**Application Reference:** 6/2017/2852/COND

**Proposed development at:** Stonehills House Stonehills Welwyn Garden City AL8 6NH

**Proposal:** Submission of details pursuant to conditions 4 (external material samples) and 5 (details of dormer and replacement windows) on planning permission 6/2016/0818/MAJ

Typical Replacement Window Detail - Scale 1:10

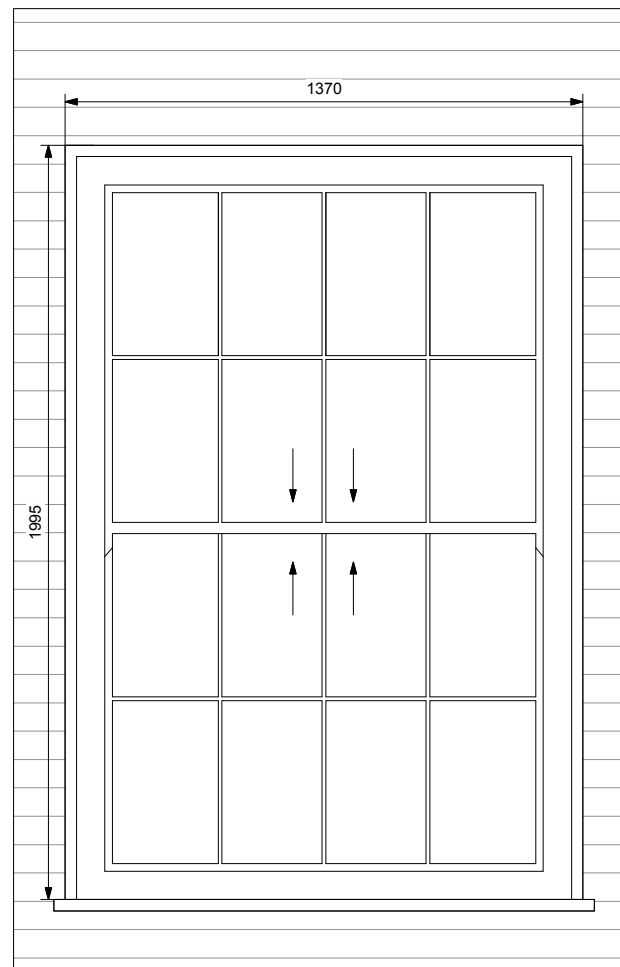
Condition 5 requires the submission of 1:20 elevations and 1:2 detailed sections including through glazing bars of new dormer and proposed replacement windows be prior to commencement of the works on site. The 1:10 scale and measured sections are sufficient to assess the submitted details and the 1:2 detailed section and plan has also been submitted and are of appropriate scale.

A typical replacement window detail drawing at a 1:10 scale has been included in the drawings and an additional detailed plan at a 1:2 scale. However, concern was previously raised with the planning application, concerning the details provided of the glazing bars and concern regarding these appearing fake and applied to one large sheet of glass for each sash which gives a bland appearance without the liveliness of separate panes.

Detail Section - 1:2

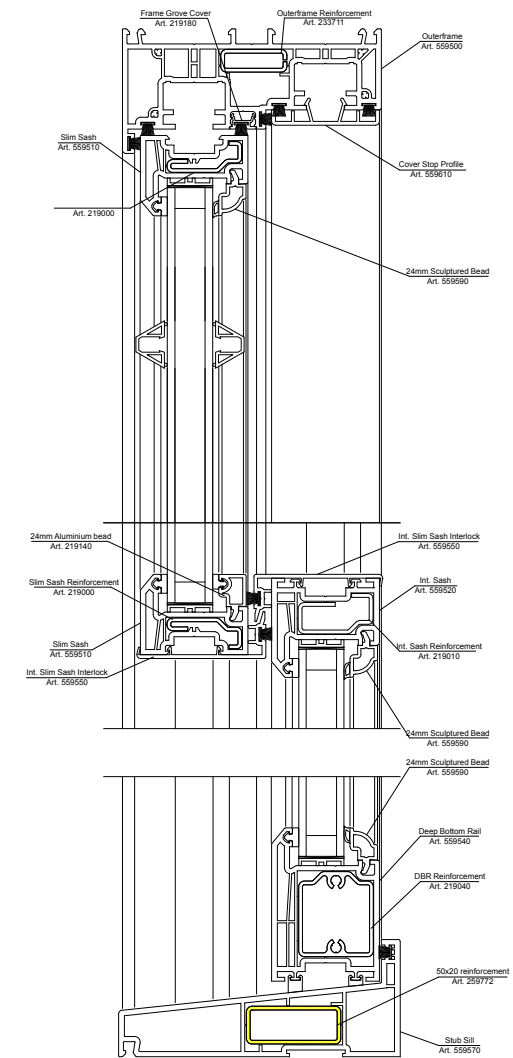
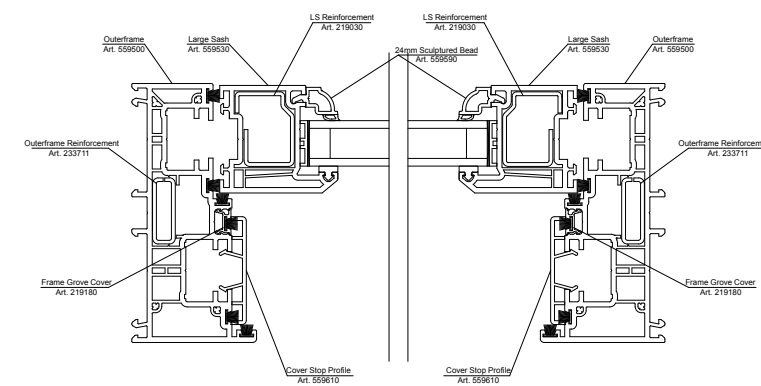
The previous application reference 6/2017/1546/COND acknowledges that the sectional details failed to include through glazing bars required in order to establish the depth of the Georgian glazing bars. It is considered that insufficient details have been provided to establish the depth of such glazing bars, in order to determine whether these have been profiled to match the existing on the exterior and therefore whether these would preserve and enhance the special character and appearance of the Conservation Area. In accordance with the above, the details provided are not acceptable pursuant to Condition 5, and this condition has been refused.
